A38 DERBY JUNCTIONS DCO APPLICATION

RESPONSE OF BREADSALL PARISH COUNCIL TO THE EXAMINING AUTHORITY'S SECOND WRITTEN QUESTIONS.

Drawing Title  
FIGURE 2.7  
LITTLE EATON JUNCTION  
GENERAL ARRANGEMENT

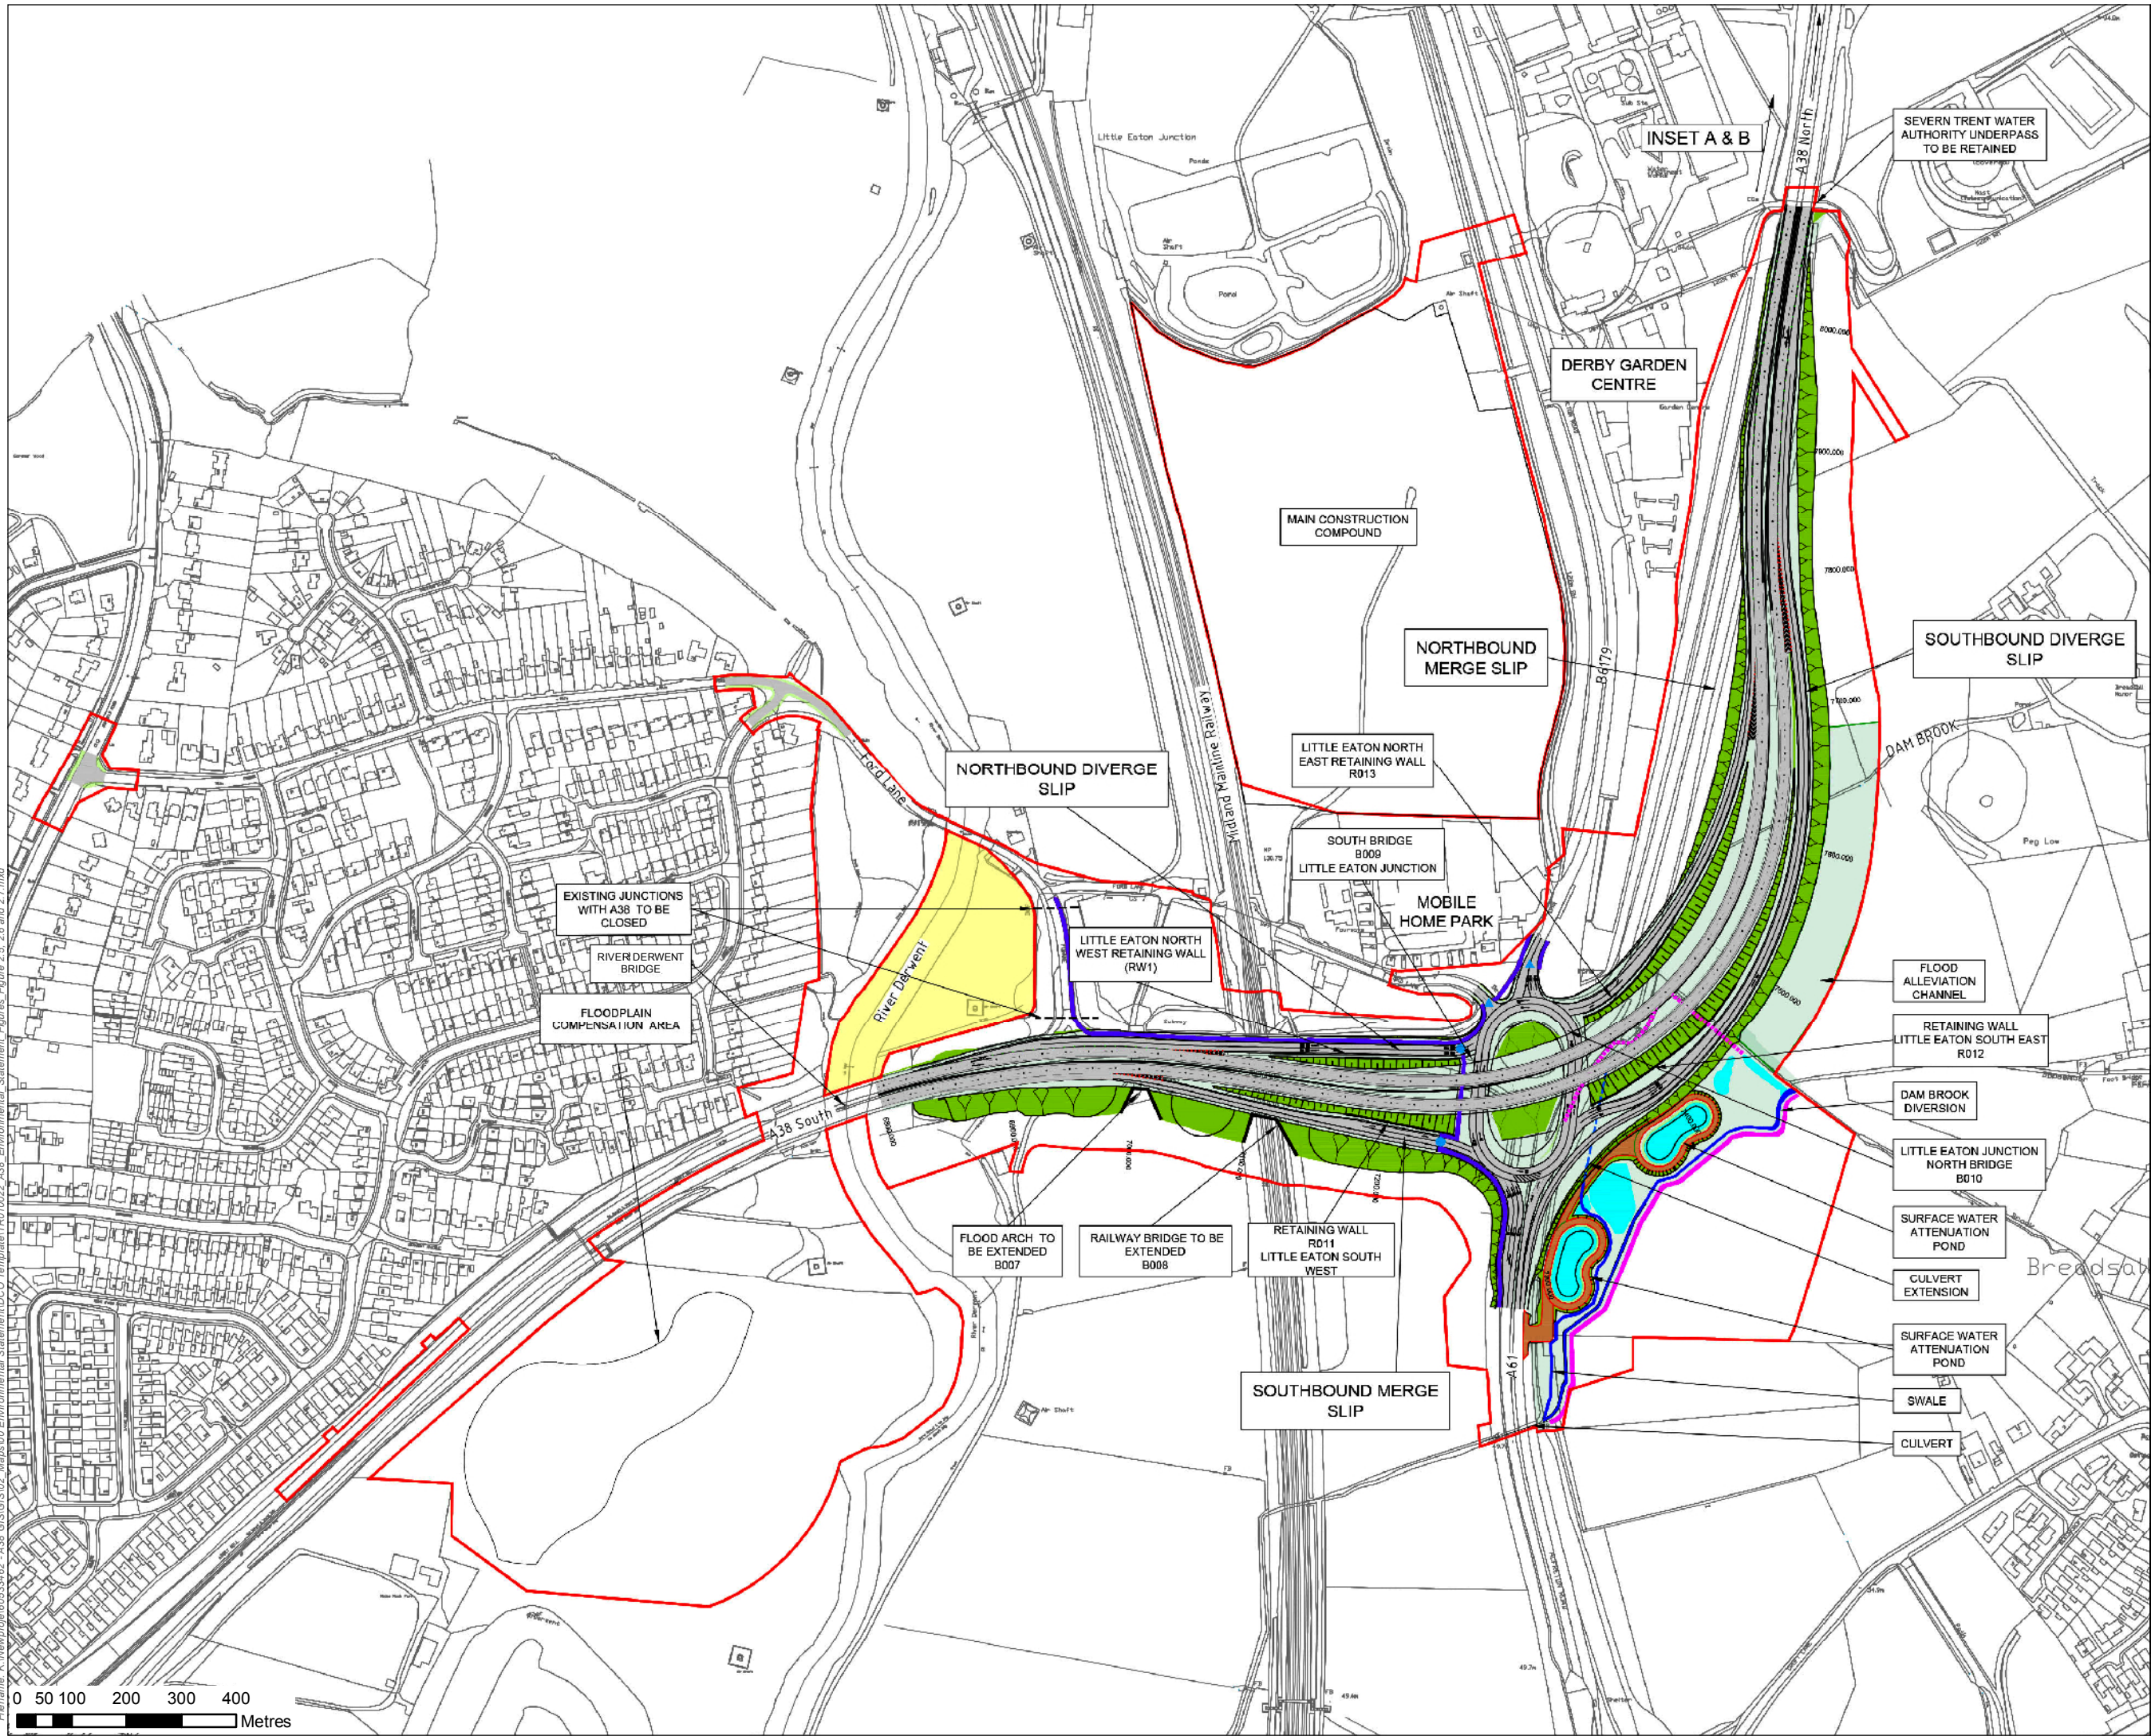
As far as the Parish Council is aware the plan submitted by HE in Rep 3-016 correctly shows the current alignment of FP3. Although HE appears to believe that some sort of diversion of this route has already taken place the Parish Council is unaware of any such diversion being formally approved. The County Council representatives were similarly unaware of any diversion at the hearing

The present alignment of FP3 takes the pedestrian directly from Breadsall to the edge of the existing A38 southern slip road and then heads southwards immediately alongside the slip road as far as the southern side of the existing roundabout, where a dangerous crossing point is located. For the pedestrian wishing to reach the northern side of the existing roundabout there is a more direct route available by leaving FP3 where it first reaches the existing slip road and then simply crossing the slip road and the A38 main carriageway just to the north of the roundabout. The Parish Council has never suggested that FP3 actually crosses the A38, but this is a route which is available to pedestrians. The Parish Council is requesting that HE replicates this useful, direct route by providing a footpath route across the slip roads and beneath the A38 bridge immediately to the north of the new junction.

HE appears in its proposals to be suggesting that pedestrians could cross the A61 on the alignment of FP1 some way to the south of the roundabout and proposes to divert FP3 to join with FP1 to facilitate this. This is quite unacceptable as the A61 at this point is a high-speed dual carriageway and far more dangerous than the direct crossing point referred to in the third paragraph above.

HE also suggest that pedestrians wishing to walk from Breadsall to the northern side of the existing roundabout could walk southward along Croft Lane and Old Croft Lane to the proposed new Toucan crossing over the A61 and then northward along the western side of the A61. This is true but results in a major detour in the order of 660 metres and represents a most unattractive route entirely on or alongside roads.

Both HE and the County Council suggest that the proposed diversion of FP3 would create a circular recreational route together with FP1 to the east of the A38. This may be true, but the general objective of footpath users is to reach a destination, not to go round in circles! This, while not unwelcome, is likely to be of interest only to dogwalkers and is certainly no compensation for the loss of the direct route from Breadsall to the northern side of the A38/A61 roundabout. The Parish Council therefore opposes the loss of FP3 as a direct route to the B6179 but is quite happy to see a new link between FP3 and FP1 as shown in blue on the plan submitted by HE with REP 3-016. The County Council suggests a more direct alignment of the new link than the one shown by HE. The Parish Council has no objection to this, but it is possible that the HE proposal follows the boundary of the new ponds and makes more sense on the ground.

Finally, the Parish Council requests a definite commitment to provide a Toucan crossing over the A61 at or near Old Croft Lane. It is understood that funding has been secured from HE but the County Council is still considering design issues. The Toucan crossing is vital to provide a safe pedestrian and cycling route between Breadsall and the western side of the A61 and it is understood that funding is to be provided as part of the A38 scheme. The Parish Council therefore requests a commitment to the Toucan crossing within the DCO or some other simultaneous agreement.
